Department of Primary Industries

Moorebank Precinct West Stage 2 (SSD 7709) Comment on the Environmental Impact Statement

14 December 2016

TYPICAL WALLED BASIN AND RAINGARDEN OUTLET PLAN
NTS

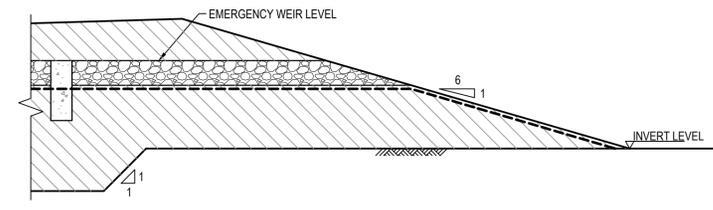
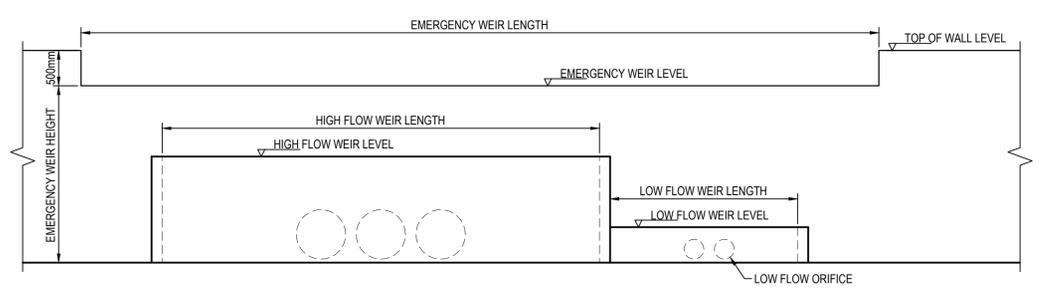
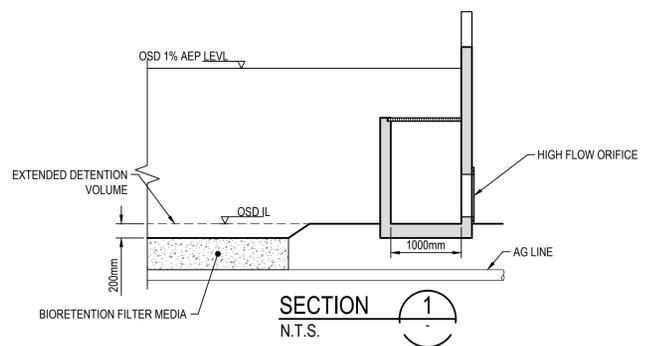
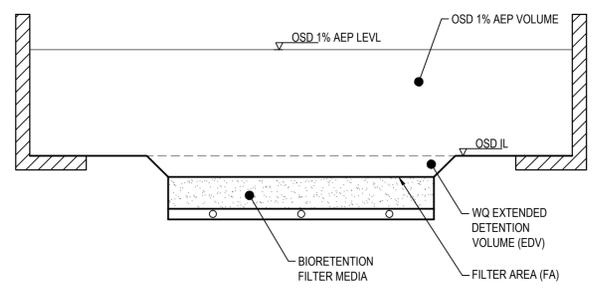
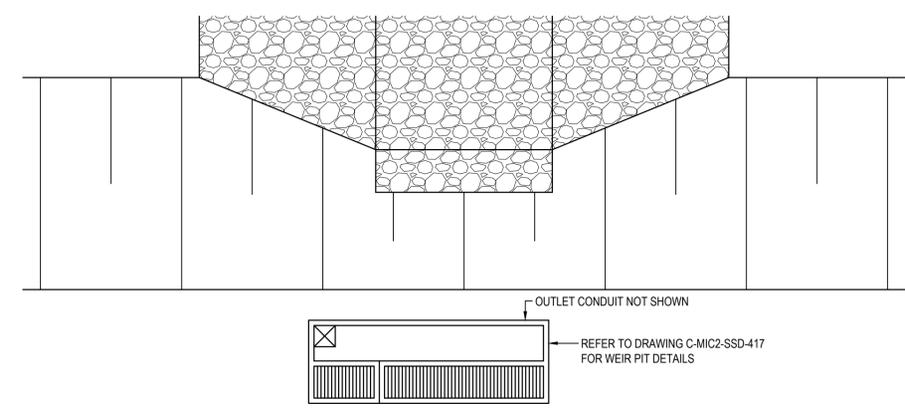
- The proponent should provide further detail and justification of the width of drainage channel outlets to be used during construction. The proponent should investigate and advise whether other options are available to minimise the outlet width and the potential impacts on the river bank profile and riparian connectivity. Outlet structures should be constructed in accordance with DPI Water's [Guidelines for outlet structures on waterfront land \(2012\)](#)
